Subject: FW: AB/88/19 Gasworks Site, Ford Road, Arundel

Engineers Comments Regarding Surface Water Drainage

APPLICATION NO: AB/88/19/PL

Description of Works: 38 No residential apartments (9 No 1-bed units & 29 No. 2-bed units) along with access, off-street parking, amenity space & enhancements to the local footpath network.

UPPER GROUND FLOOR PLANS

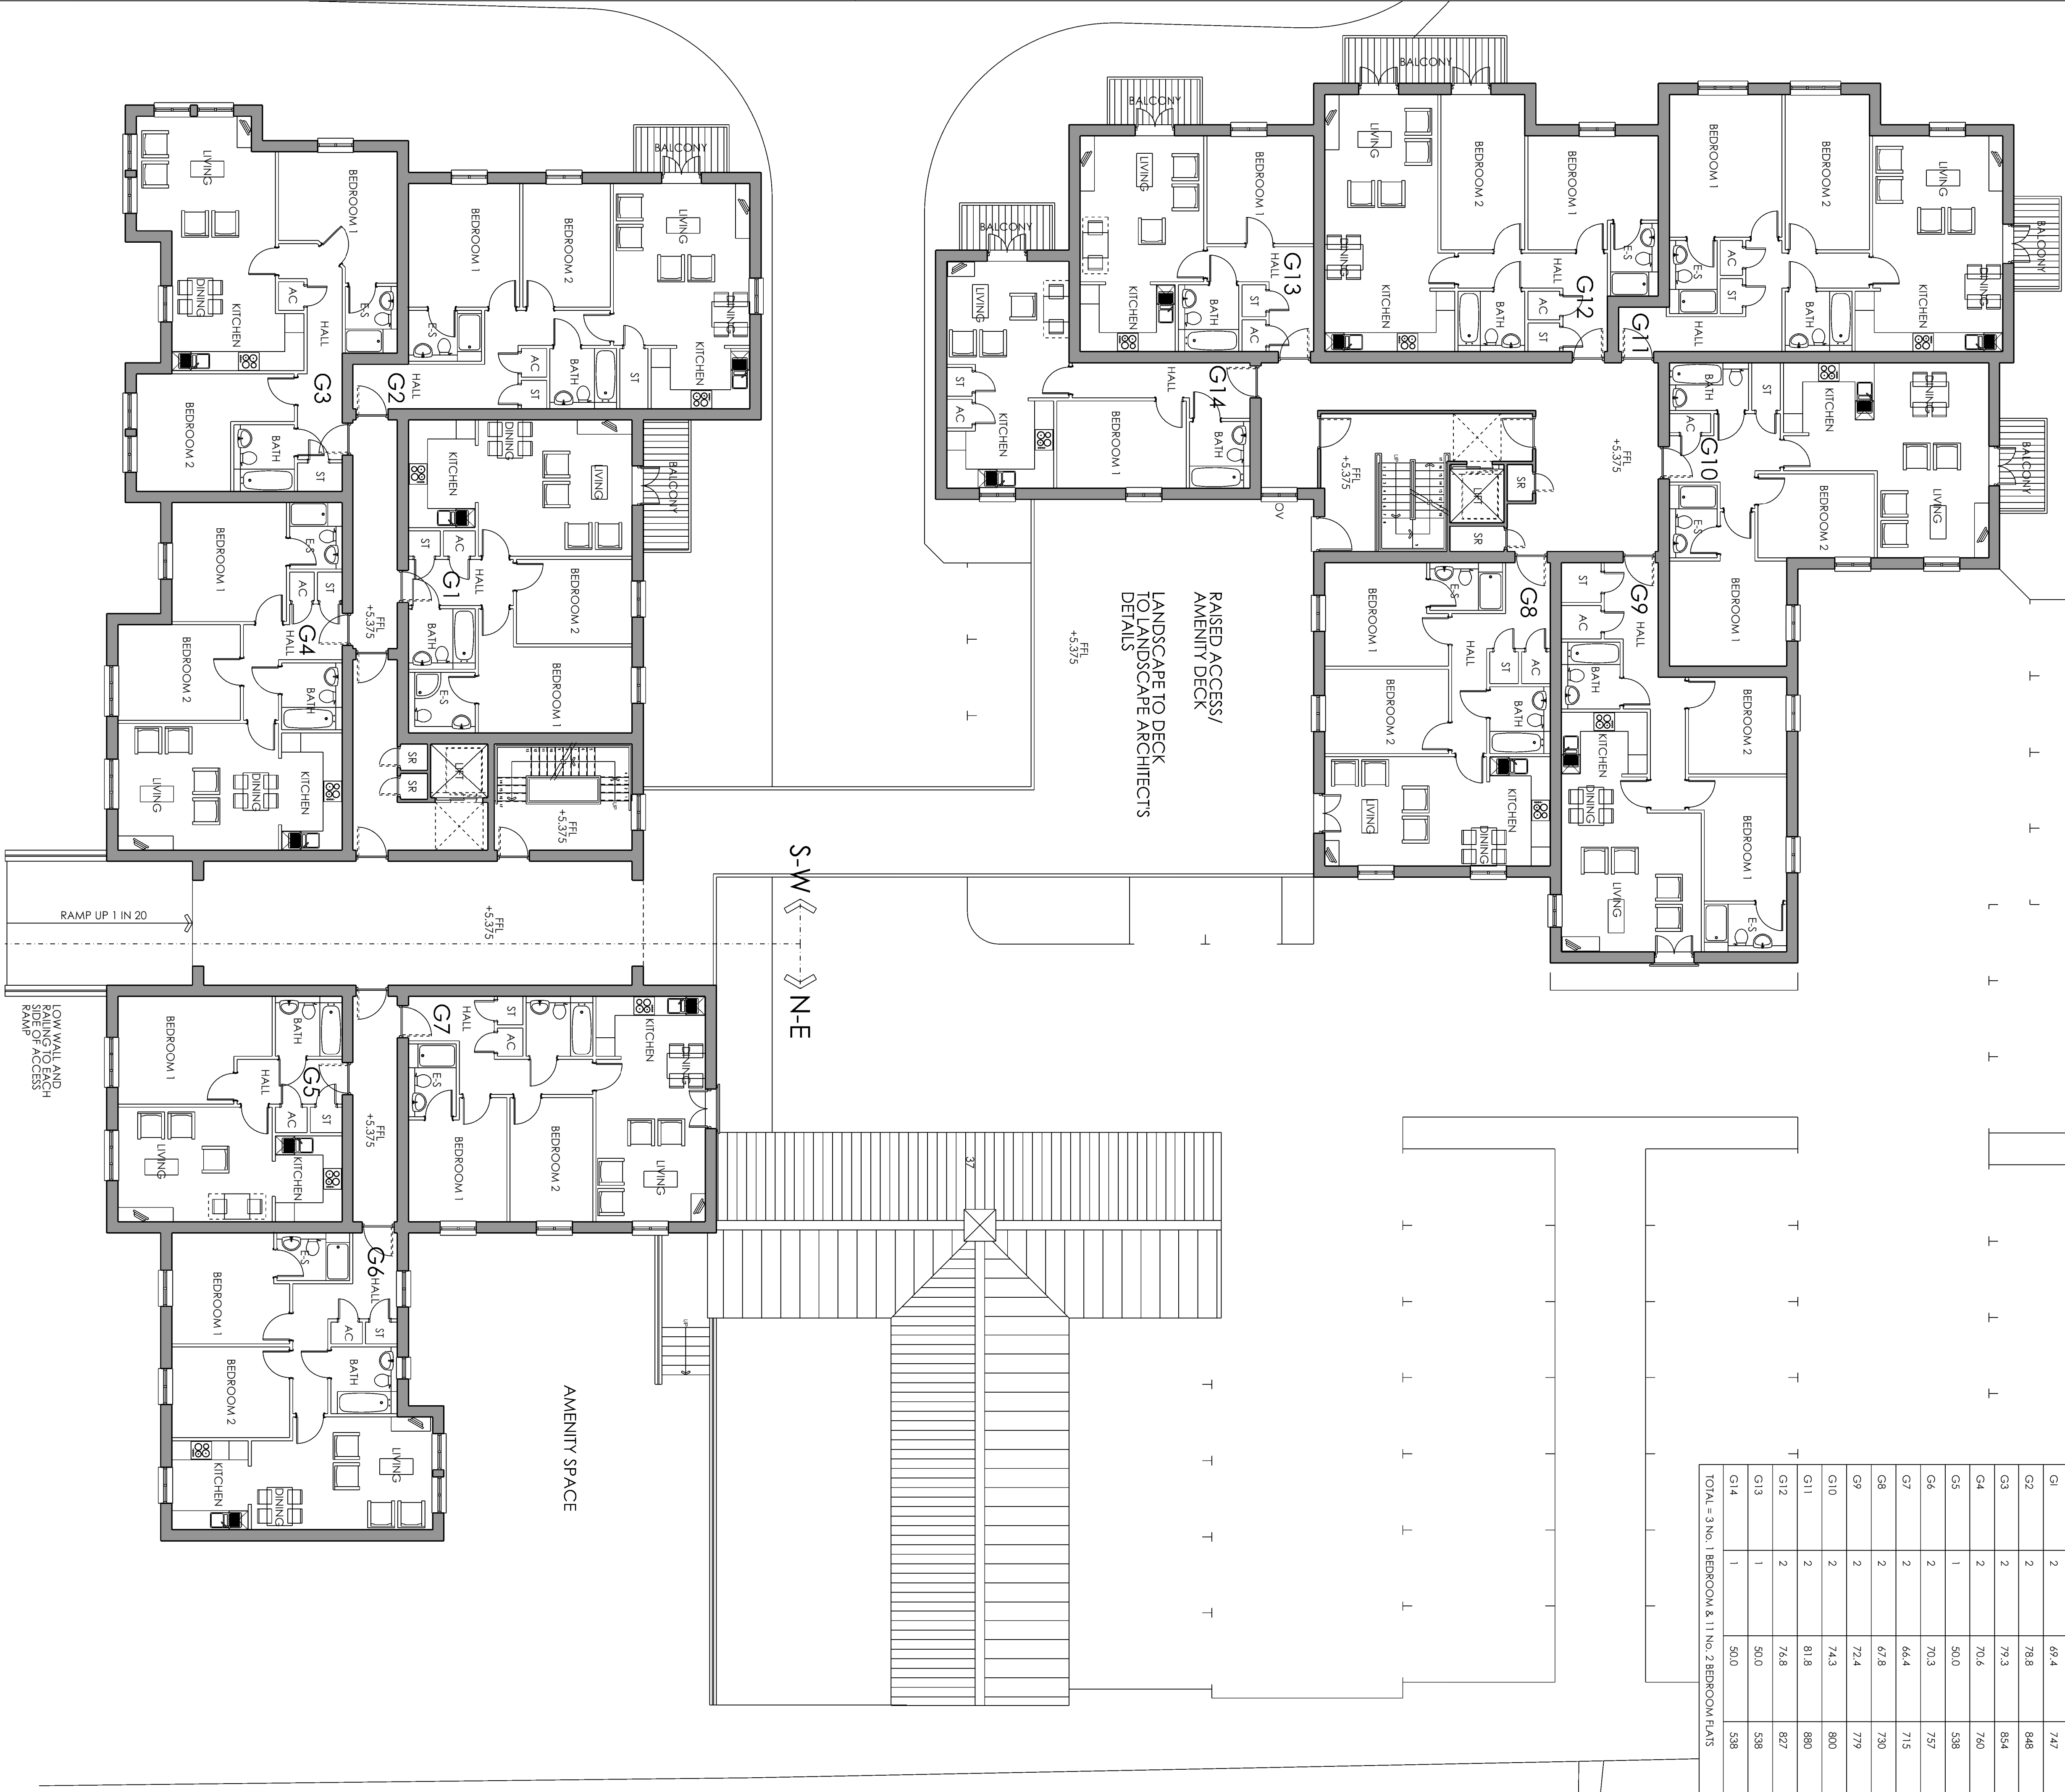
3. I also enclose previous comments from West Sussex County Council (the Lead Flood Authority) highlighting similar concerns.
4. The latest proposals from the applicants engineers are enclosed and still do not resolve all the issues in item 2 above. The current scheme involves installing storage tanks (to store roof water) just below first floor level

and above the predicted 1 in 100 year (+ 105% allowance for climate change) fluvial flood level . These tanks would then discharge into a below ground drainage system that also serves ground level car parking areas (and within the fluvial flood plain). It is unclear whether the proposed system has been designed to accommodate a 1 in 100 year storm event + 40% climate change allowance or given due consideration to the impacts of tide locking downstream. Maintenance of those tanks and potential blockage issues with their restricted outlets are also considered to be operational issues. Nevertheless, the fact that the storage tanks will discharge into a below ground drainage system that would itself be submerged/full during the fluvial flood event, is not an acceptable or sustainable solution. For these reasons and those mentioned in item 2, we will maintain our objection. If conditions were applied as mentioned by my colleague, then it is very unlikely that applicant will be able to satisfy those relating to surface water disposal, since there currently appears to be no sustainable/workable solution given the site constraints.
